ENG-CDR21014-R4-DR.pdf Markup Summary

Galloway
 1155 Kelly Johnson Blvd., Suite 305
 Colorado Springs, CO 80920
 719.900.7220
GallowayUS.com

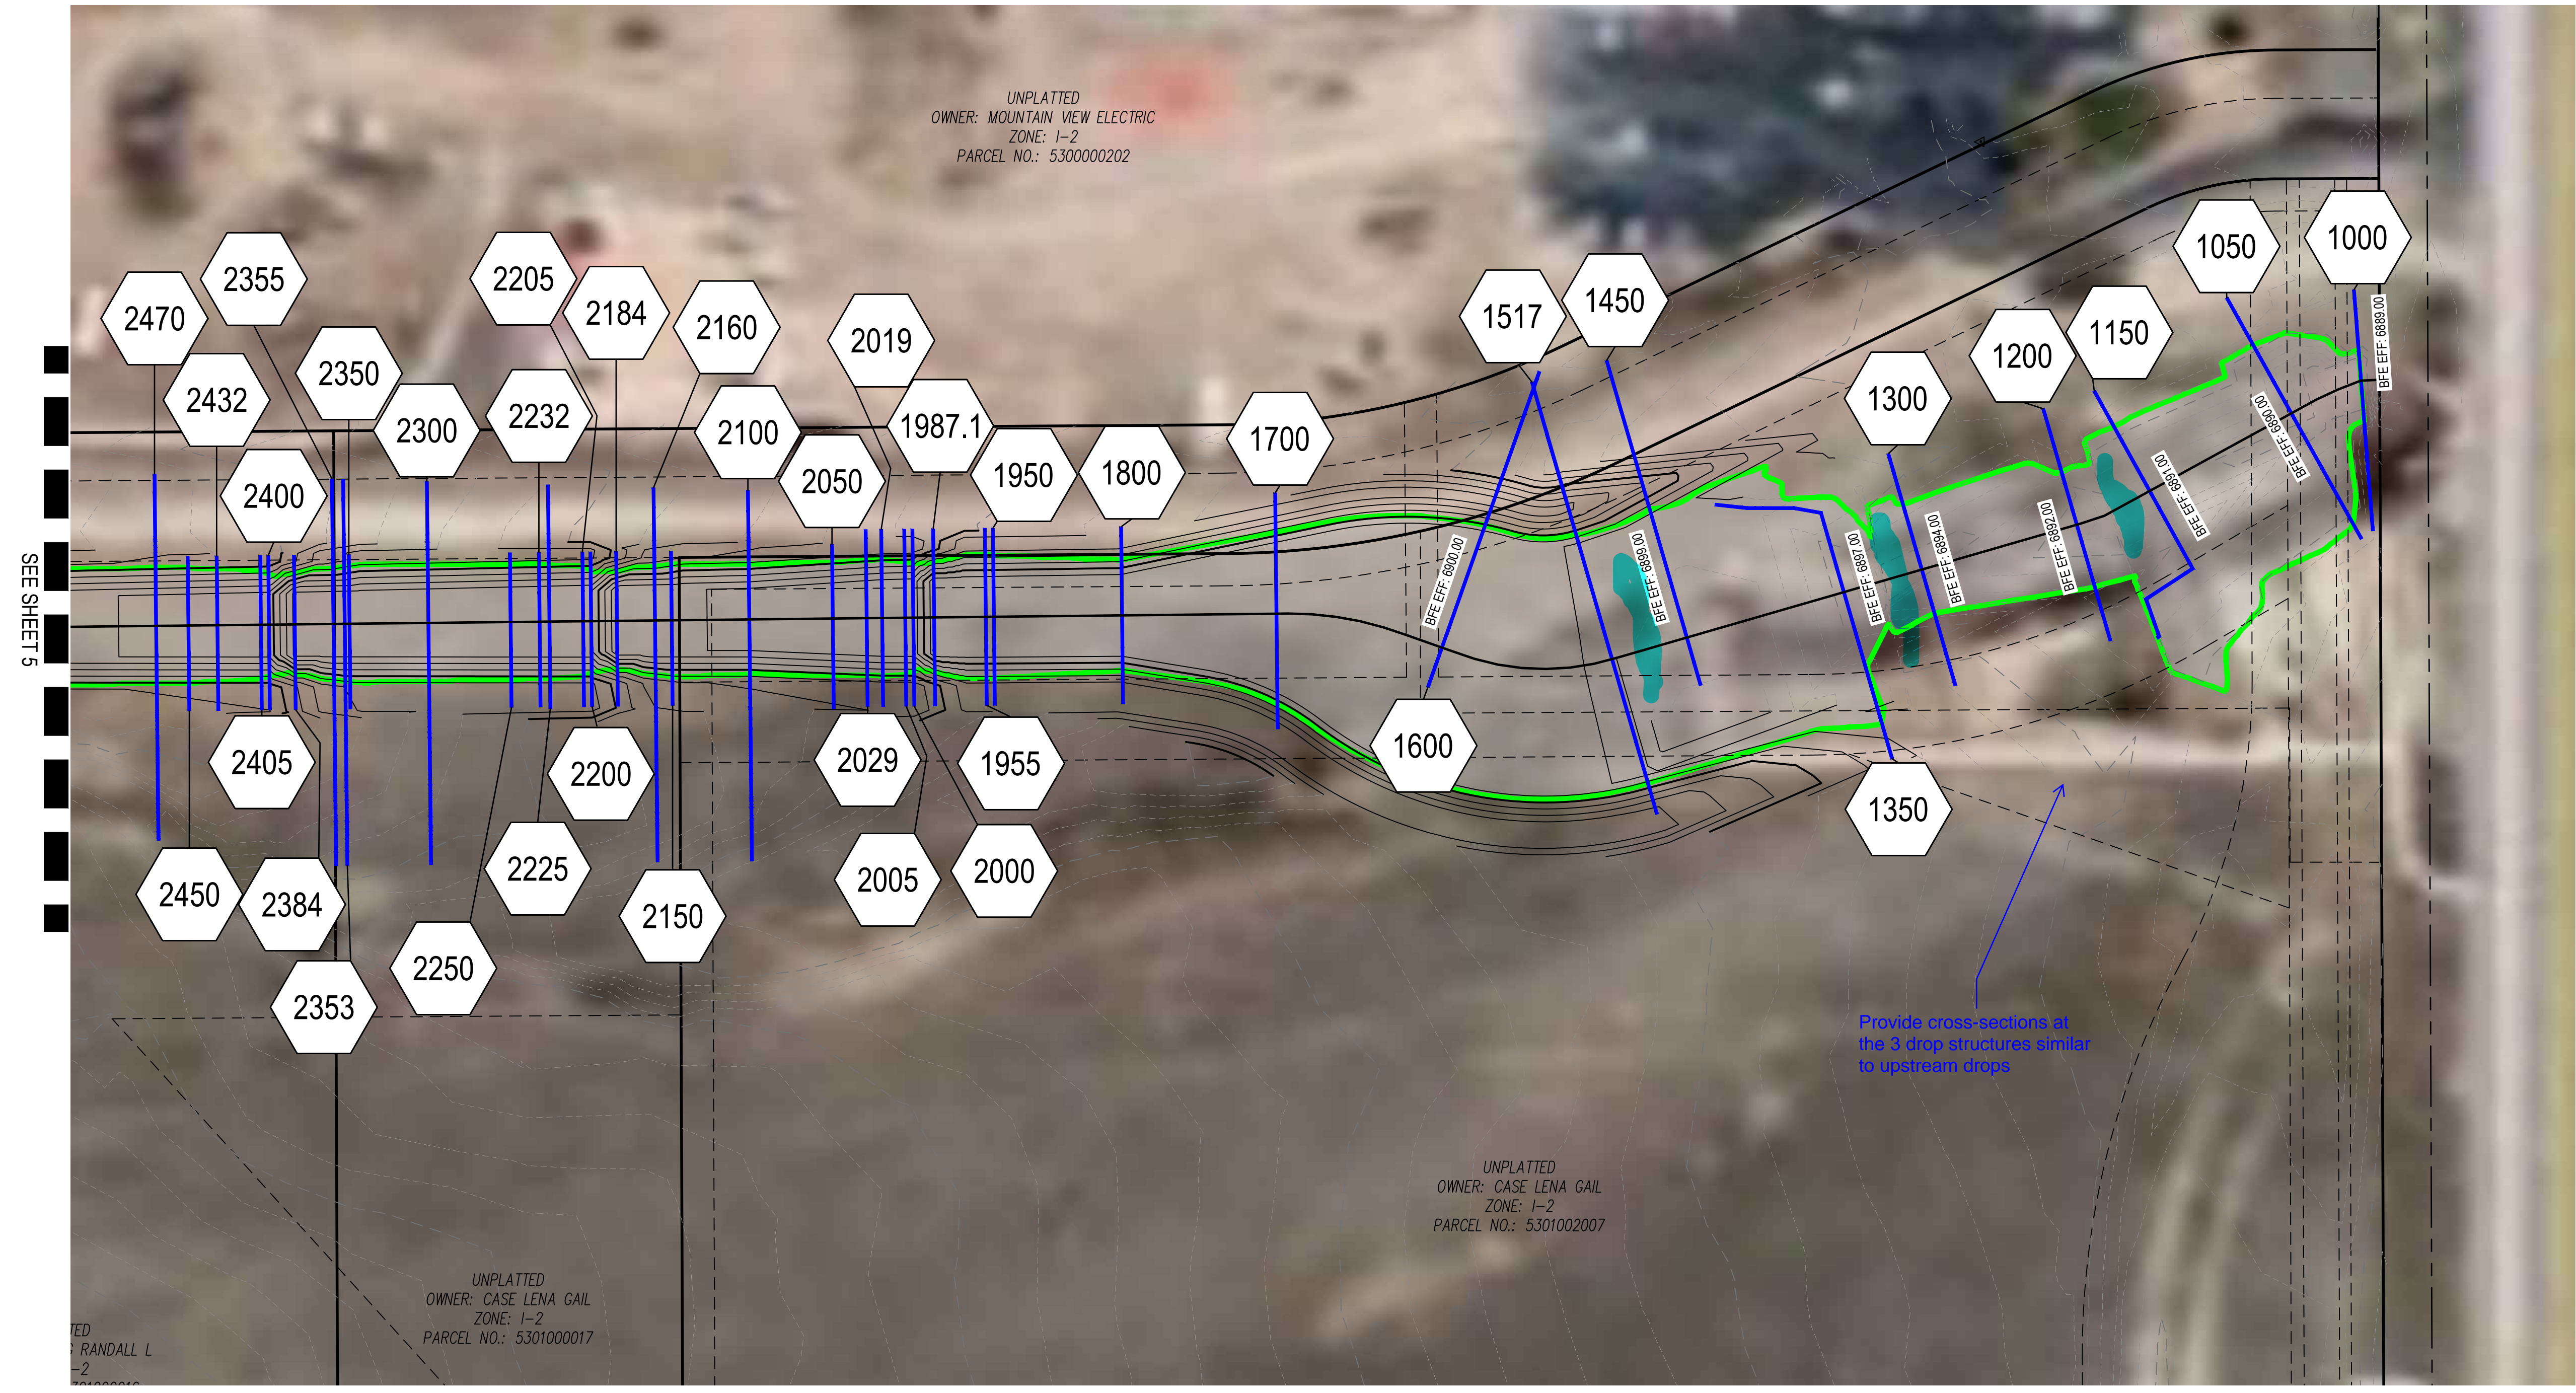
Provide shear stress calculations and specifically address in the low flow channel and bends.

provide shear stresses for this channel
